Our reference: 23/02149/PREAPP
Date: 02 October 2023

Re: Part one/part two storey side and rear extensions, front entrance canopy and alterations to roofline to provide rooms in roofspace. Outbuilding and installation of front wall and gates.

38 Parkwood Road, Bexley, Kent, DA5 3NW

Title
Wall & Gate Drawing

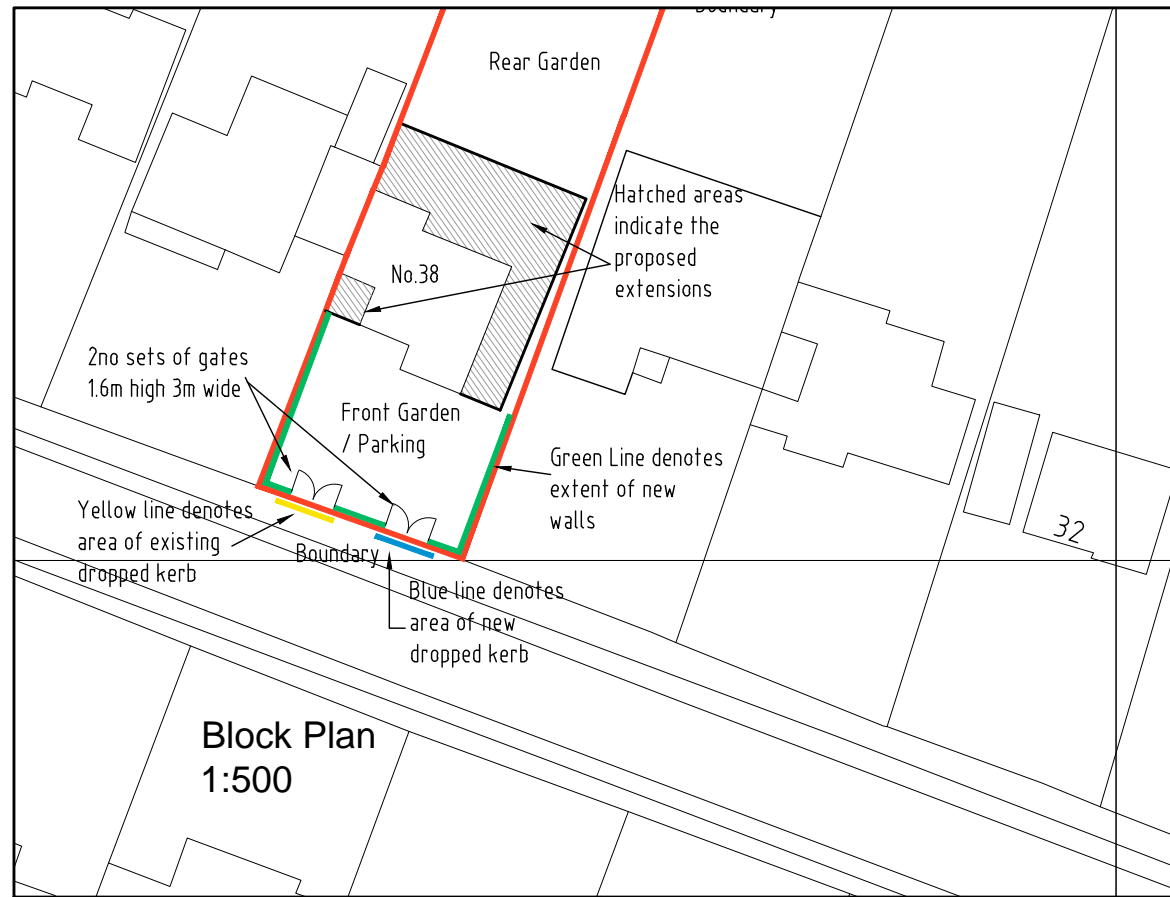
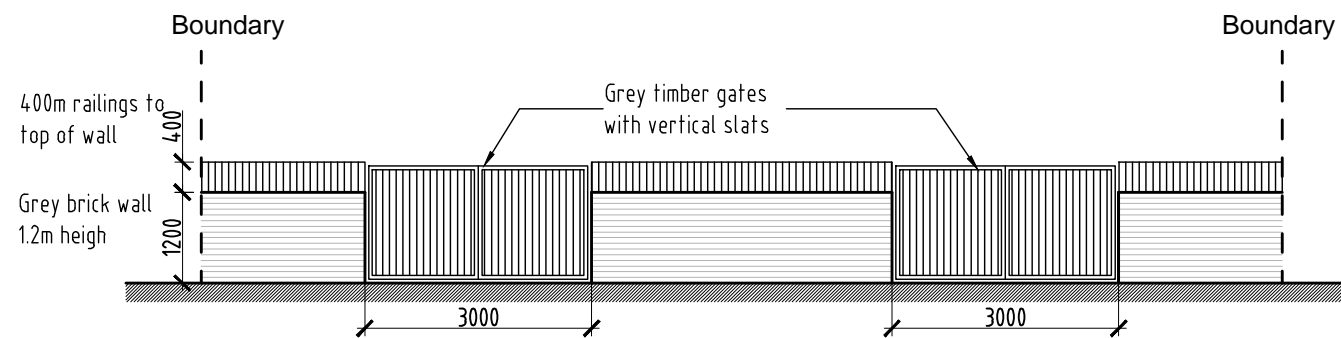
<p>Does the proposed development respect and accord to the established local character?</p> <p>Officer comment:</p> <ul style="list-style-type: none"> • Parkwood Road is characterised by two-storey dwellings of differing design and character. Large additions are common developments along Parkwood Road. Therefore, no objection is raised in principle to the proposed massing subject to neighbouring amenity. • As existing 38 Parkwood Road appears smaller in comparison to its neighbouring properties as it remains as originally built compared to other properties which have been significantly extended. The proposed development would increase the existing floorspace by 126%. However, the proposal would appear appropriate and proportionate in terms of the context within this part of Parkwood Road. • The proposed development would incorporate a front wall and gate. The proposed front wall is 1.6m in height. The majority of walls along Parkwood Road are 1m in height. The proposal would need to be reduced to at least 1.2m in height to appear acceptable within the street scene. 	YES

- The proposed front wall should be reduced to a maximum of 1.2m in height to appear acceptable within the street scene.
